OBJECTION

Application Ref: 22/01109/FUL, High Ridge, Top Street, Askham, NG22 0RP

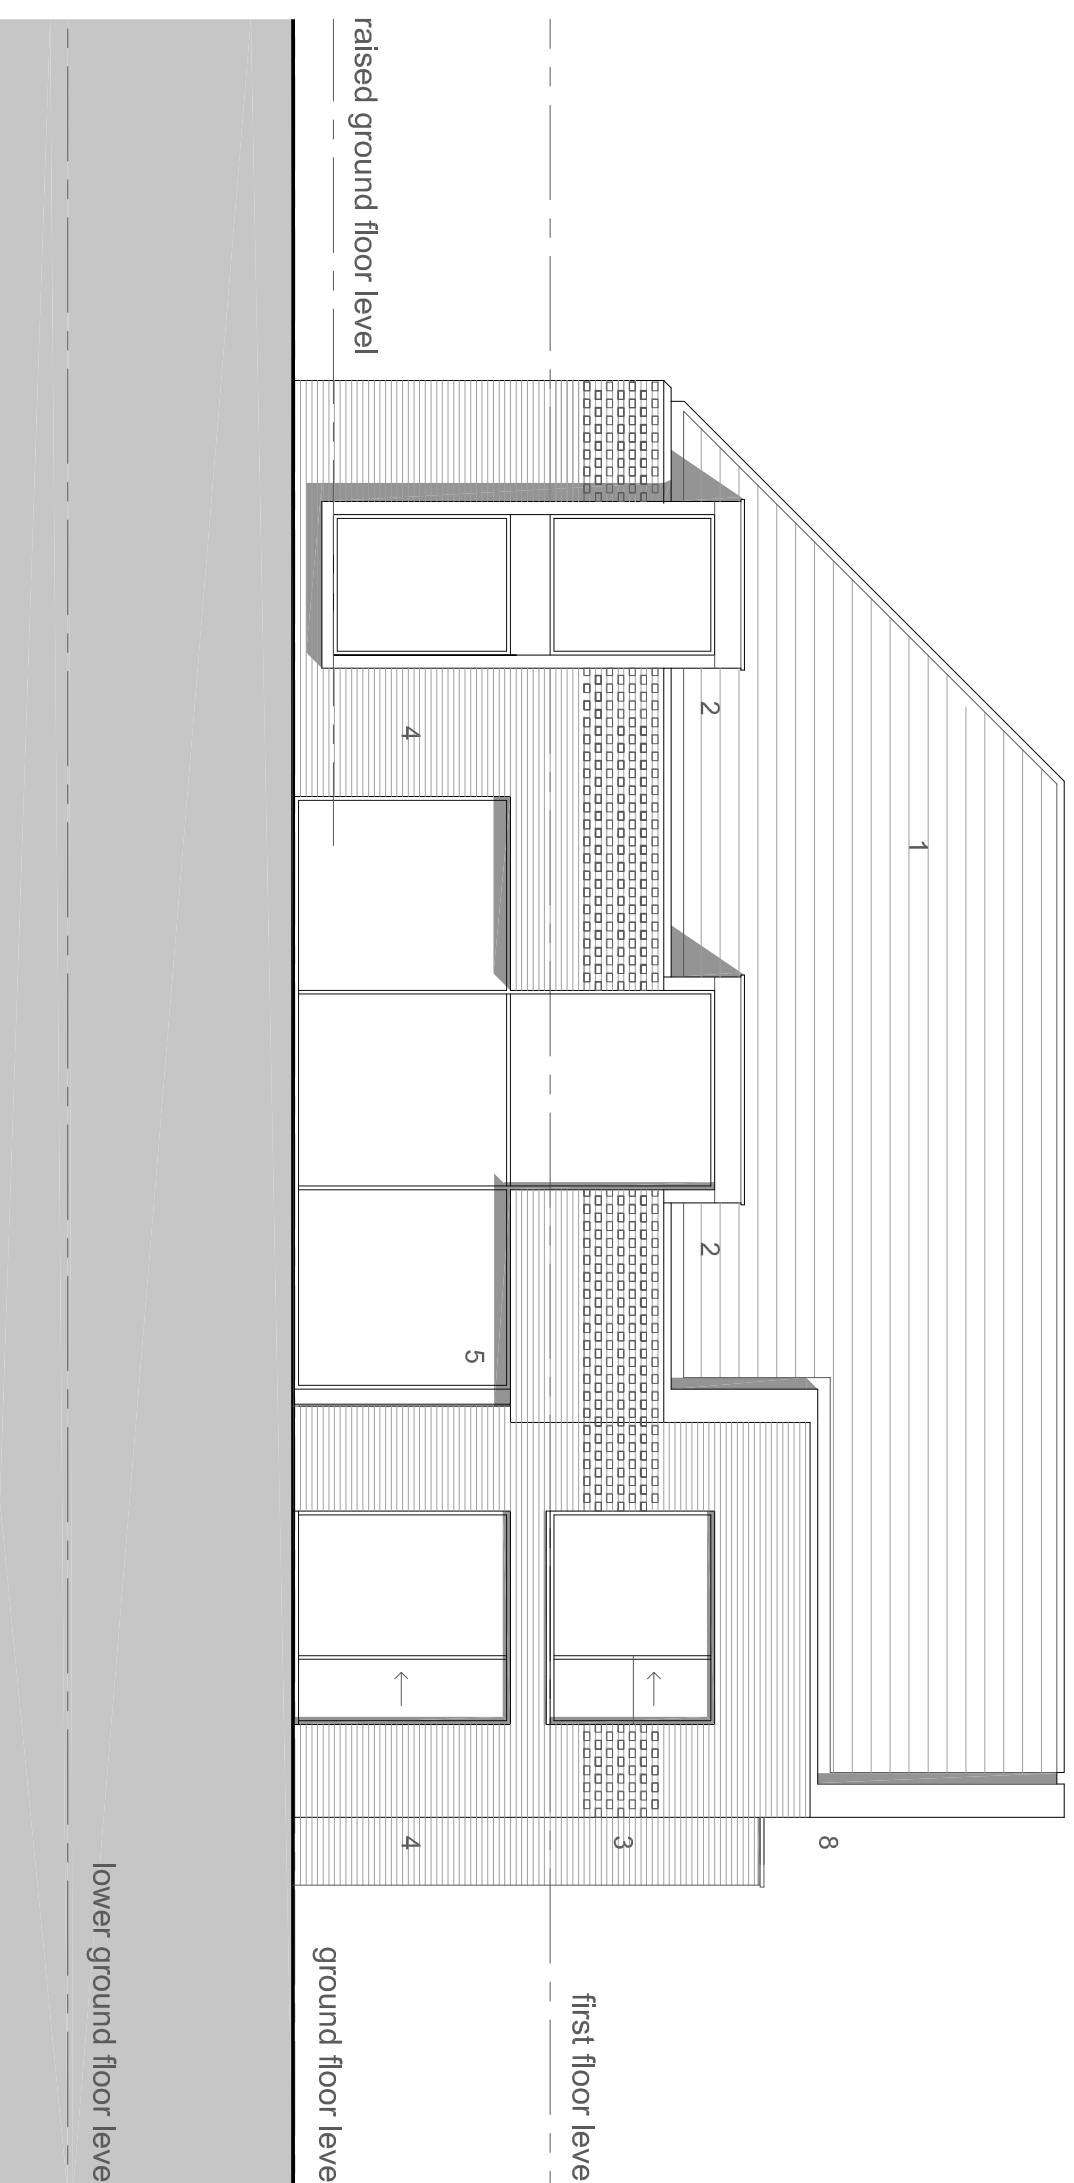
The materials proposed are of high quality, intended to reflect the local architecture and there are details which can be seen in local buildings. The scale of the development and the proportions of glass and brick do not relate to local character. This amounts to a pastiche. A large modern building has had some design elements from local architecture included without altering the fact that it is a massive construction using large areas of glass.

Height and Massing study in relation to neighbouring houses

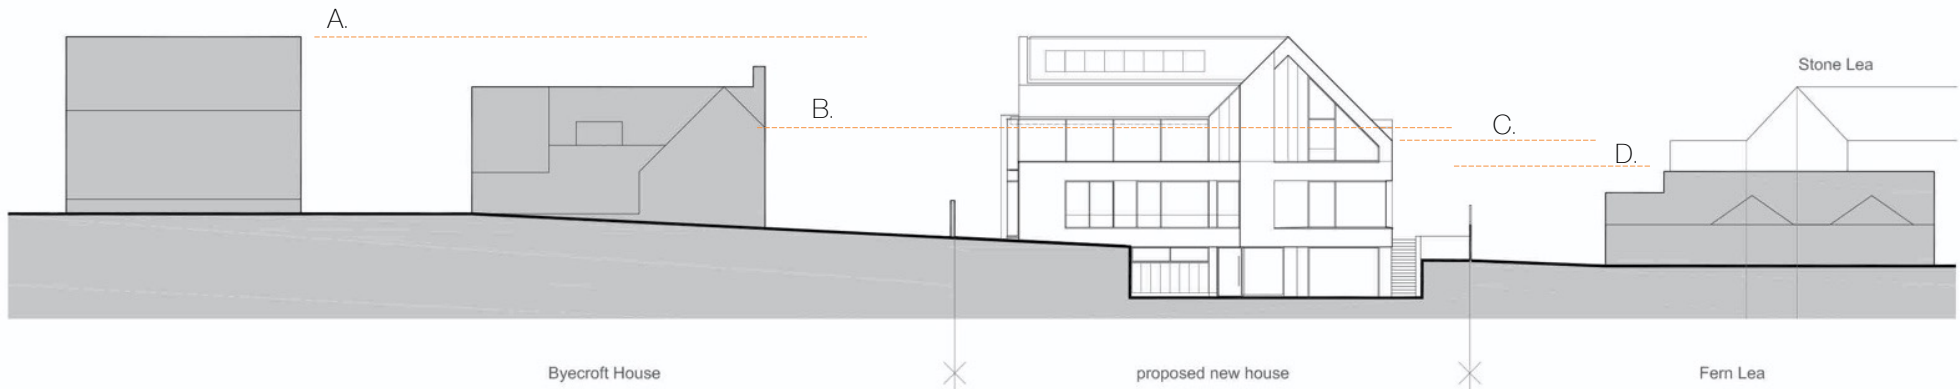
The proposed build is out of scale with the neighbouring properties. The design of three storeys requires a ridge height that has been aligned with that of the house at the top of the hill. The natural fall in the land of Top Street is currently followed by the roof lines. This natural and pleasing line can clearly be seen from our bedroom window. The

higher ridge line of the proposal does not take into account the local topography. In fact there is no proper topographical analysis. Viewed from our direction there will be a jarring effect in the ridge lines, this will be much greater when viewed from the front. Page 9 of the Parish Presentation 13.09.22 clearly shows how the new house dominates, and is out of scale with Byecroft House, itself quite a large building. The buildings further down are smaller and therefore even more overpowered.
